**Consultation Response from KC,
Trees**

**2025/91202 Unit 800, Bretton Park Industrial Estate, Bretton Park Way, Savile Town, Dewsbury,
WF12 9BS**

**Erection of three storey office extension, alteration of hard surfaced area to car park, with
associated works including landscaping.**

PROPOSED SITE PLAN

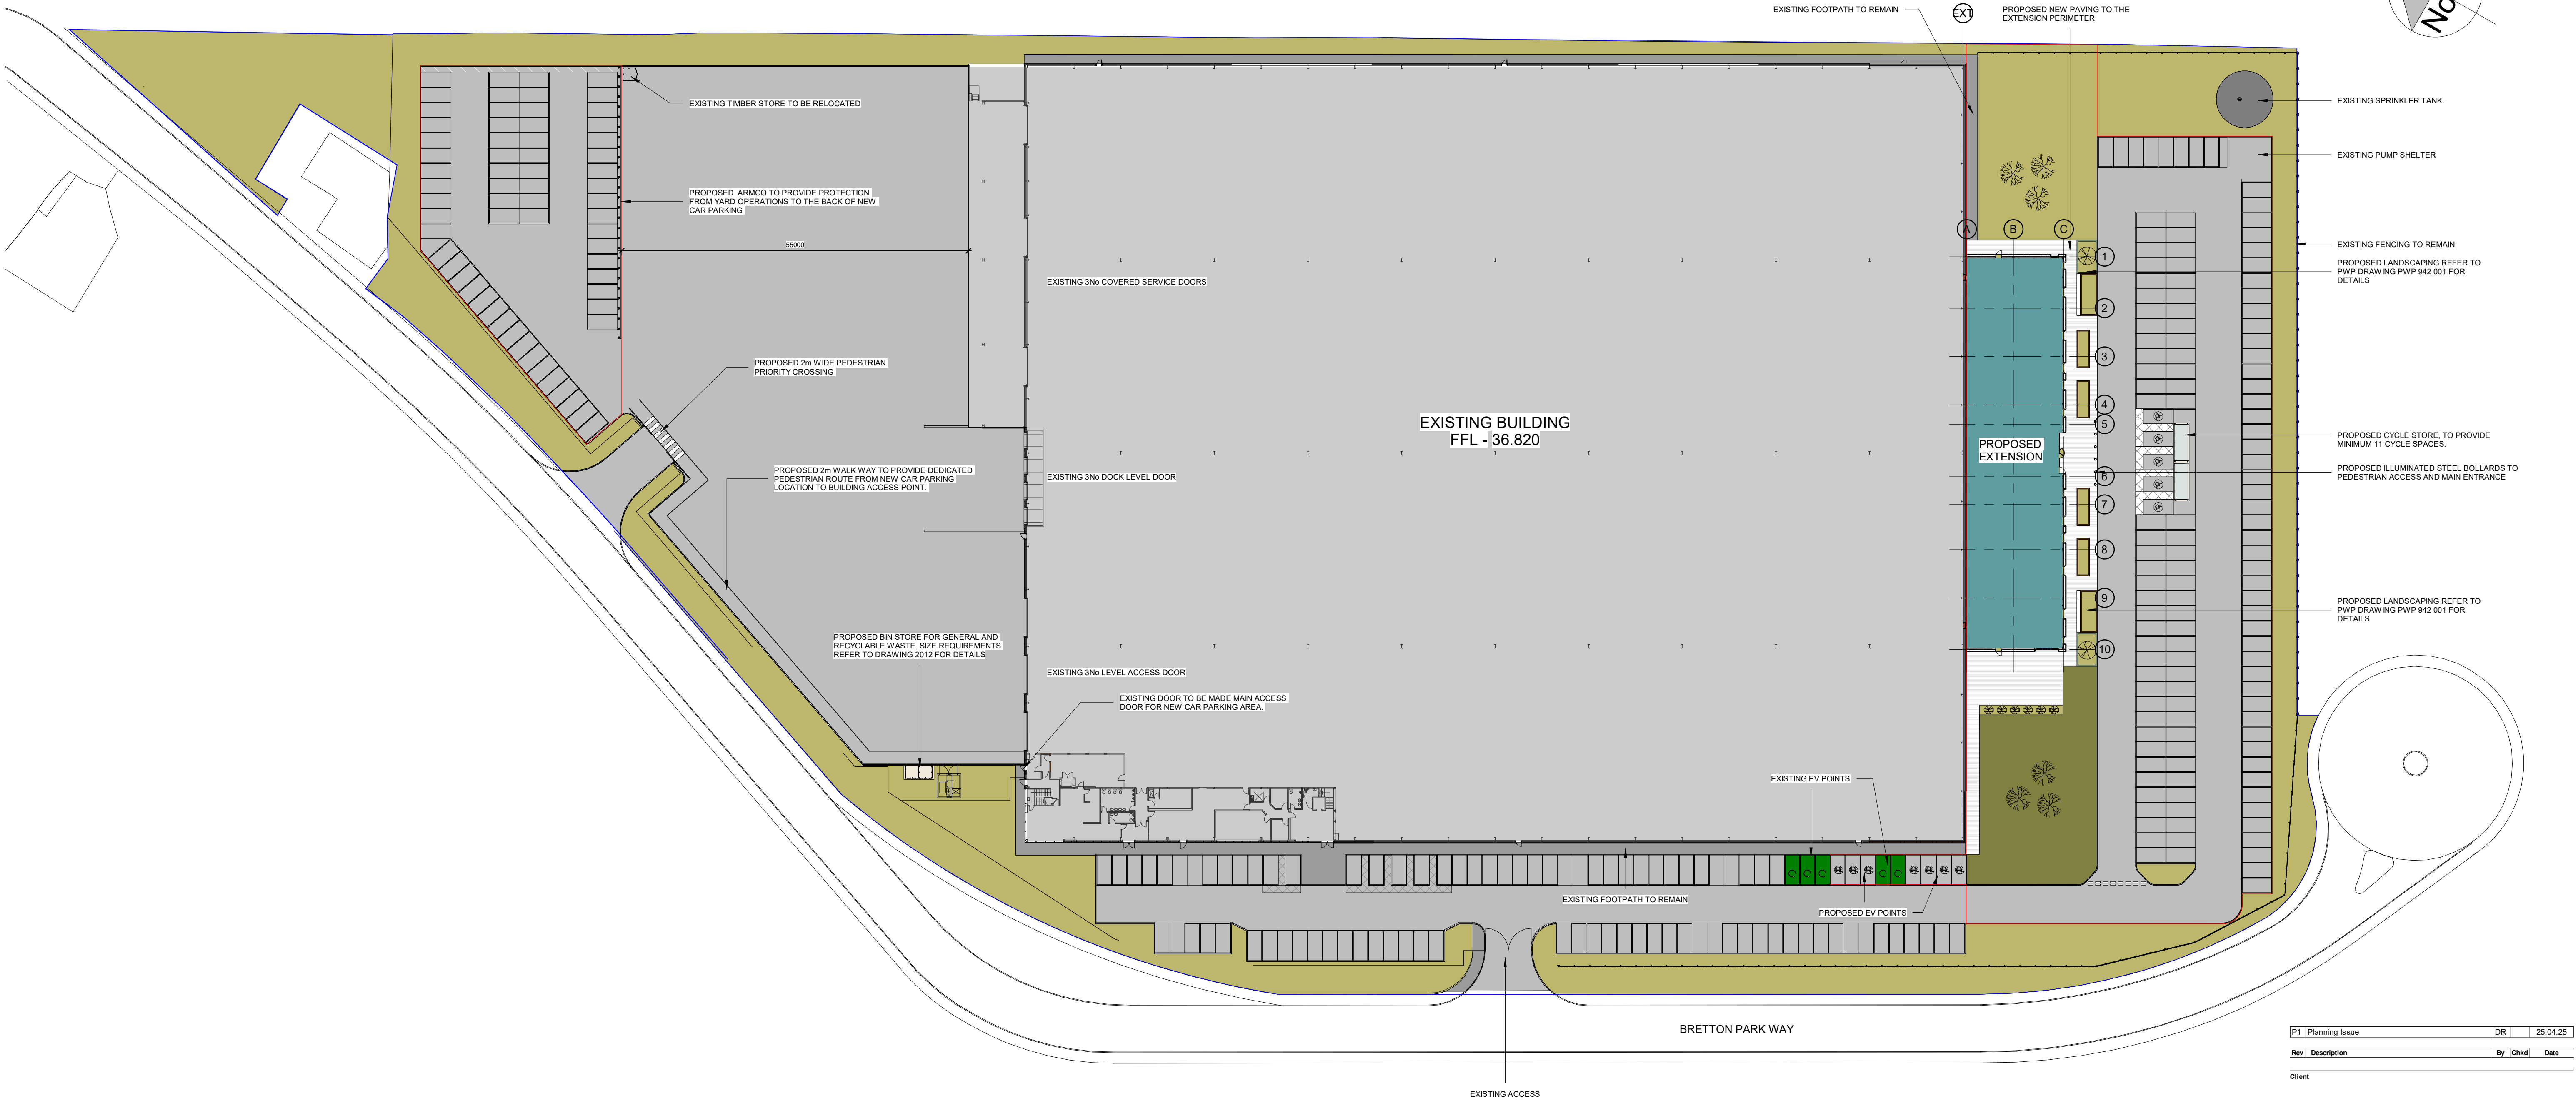
There are trees within the site, however no information regarding the existing trees has been supplied in support of this planning application. It is acknowledged that trees will be affected due to proposed changes to the car parking and landscaping areas, and that new tree planting is proposed as part of the Landscaping Scheme.

There is a holding objection from an arboricultural perspective. The necessary documents set out in British Standard BS 5837, Trees in Relation to Design, Demolition and Construction Recommendations must be submitted in support of the planning application to show that the proposals do not conflict with adopted Kirklees local plan policy 33 and 24 (i):
